PRAIRIERIDGE FILING NO. 1

REZONE EXHIBIT

NOVEMBER 2023

PRAIRIERIDGE FILING NO. 1
PRELIMINARY PLAN
REZONE EXHIBIT
ZONING RR-0.5

## REZONE EXHIBIT

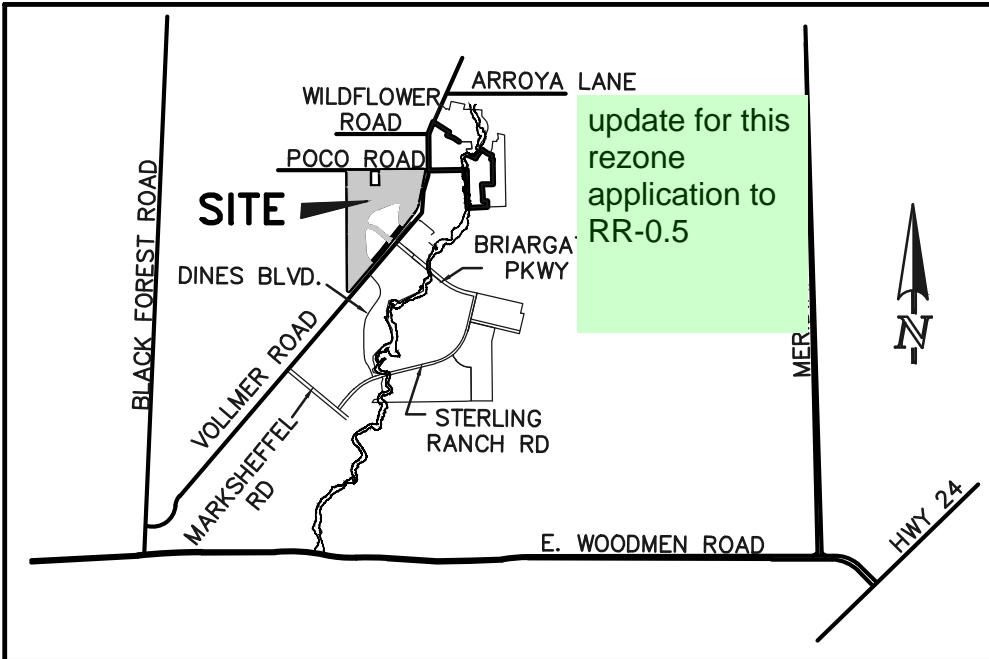
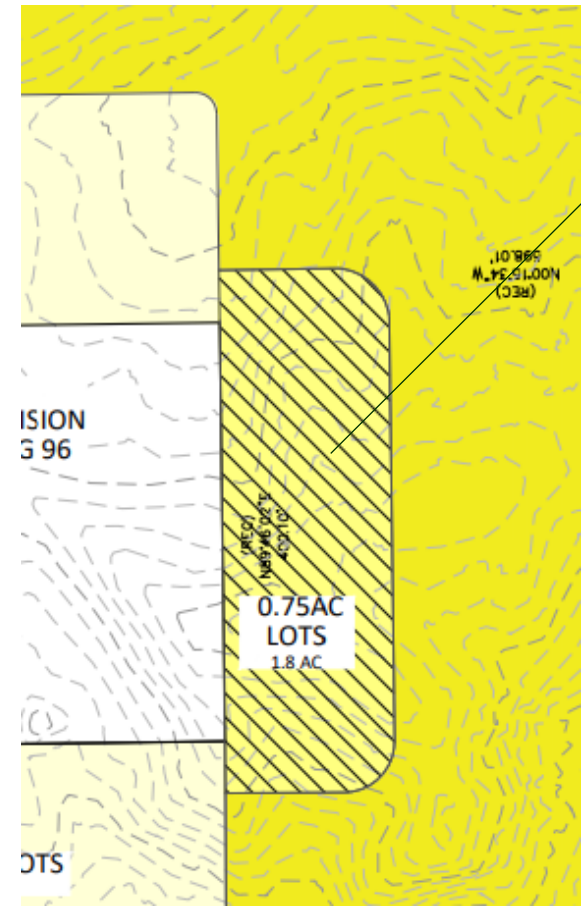
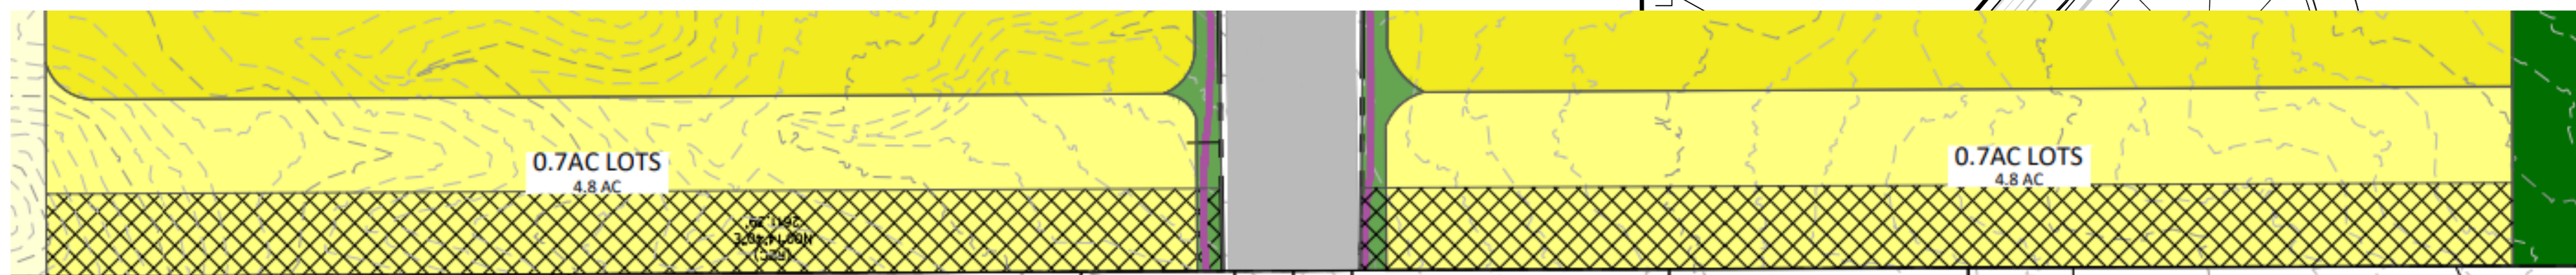
Correct Name and add RR 0.5, so these 3 Rezoning Maps can be distinguished when in packets

Add Missing Checklist Items Please

- Existing land uses and zoning on the property and within five hundred (500) feet of the boundary **ADD**
- Existing private roads **ADDED**
- Existing easements

please include this in RR0.5 so if road has to be shifted we dont have a sliver that needs to be rezoned to RR 0.5 in lieu if RS6000 as depicted which is not consistent with SKP

Add conditional setback per SKP

REVISIONS: Name Change name; this is RR 0.5 Rezone Map not Prelim Plan
REVISED

CCES RESPONSES

NO PRIVATE ROADS OR ESMTS. WITHIN THESE PARCELS.

THIS IS A ZONING EXHIBIT. RANCH RESTRICTION IS CLEARLY LABELED ON THE PRELIMINARY PLAN PER SKETCH PLAN REQUIREMENT.

THIS IS A ZONING EXHIBIT. REQUESTED INFO. IS ALL SHOWN ON PRELIMINARY PLAN PER SKETCH PLAN REQUIREMENT.
